DOC21/1033474-39

**Environmental Impact Statement
Tomago Resource Recovery Facility and Truck Depot
21D and 21F School Drive, Tomago
SSD 10447**

ATTACHMENT 1 – ADDITIONAL INFORMATION REQUIRED Tomago Resource Recovery Facility and Truck Depot

Figure E31: Predicted Ground Level PM₁₀ 24-hour Concentrations (Source Only)

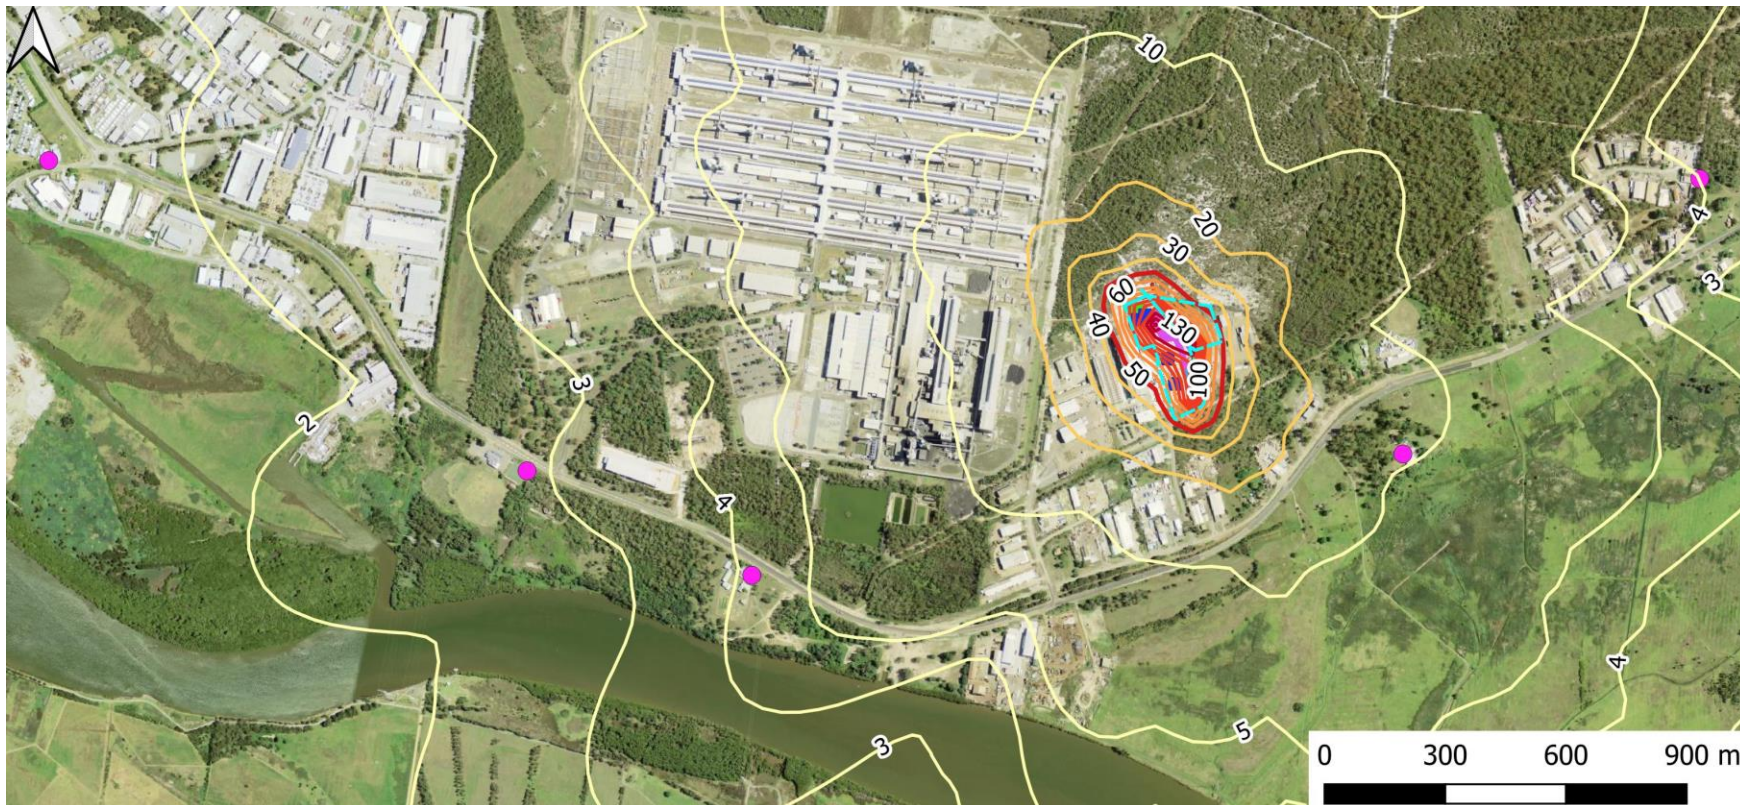
The incremental impacts of 24-hour PM10 (AQIA, Figure E31) indicate that exceedances of the criterion occur at neighbouring receptors. The modelling does not account for any potential reductions associated with conducting the operations in an enclosed building. As the impacts are for incremental only, additional exceedances would be likely at neighbouring receptors for cumulative impacts. The assessment accounts for proposed mitigation measures (including the activities being conducted inside a building) to accurately represent the proposed operations.

- i. *A revised AQIA that includes the industrial and commercial receptors in the complete assessment of air quality impacts; and*
- ii. *A revised AQIA that accounts for the control and mitigation measures that reflect the actual proposed operations (i.e. operating proposed activities within a building).*

TYPICAL SECTION OSD / INFILTRATION SYSTEM

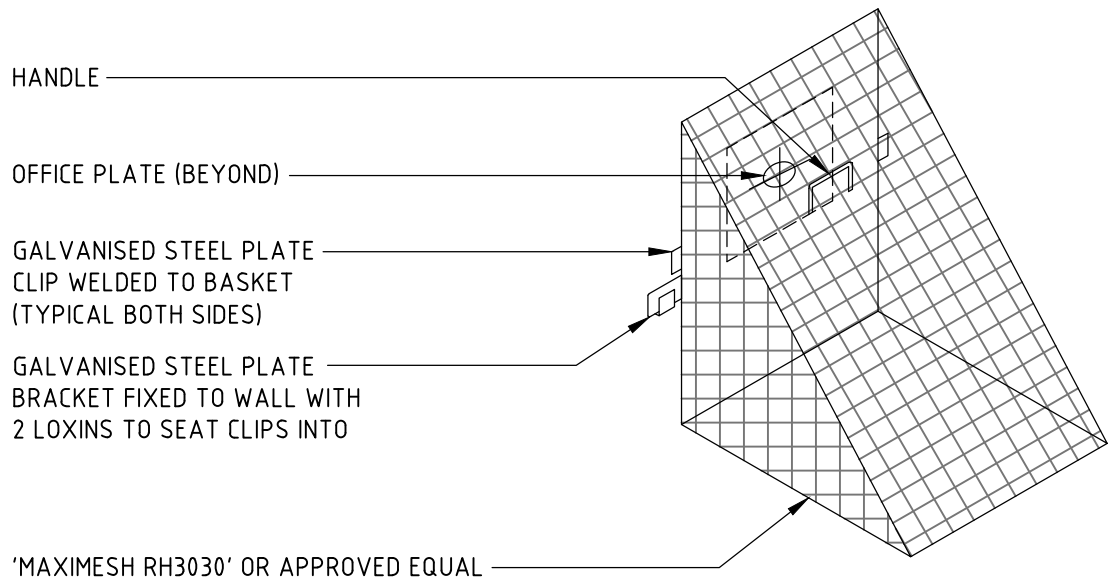
The proposed hardstand runoff treatment controls in the proposed infiltration tank located on 21F differ from those of the existing infiltrations tanks on 21D. They vary in their capacity to capture or not capture metals and hydrocarbons.

Specific particulate bound pollutant filters, particularly metal and hydrocarbon filter systems, are absent from the proposed infiltration tank in site 21F. As there are elevated concentrations of metals in the groundwater within the 21F vicinity, acceptable filters to ensure no increases to metal pollutants should be employed.

Given the three infiltration tanks in site 21D cater for the filtering of such pollutants using a different treatment system, the same treatment methods and systems should be uniformly adopted across the Premises to ensure consistency and reliability.

The EPA requires adequate justification for the differences in water quality treatment devices employed and proposed across Premises.
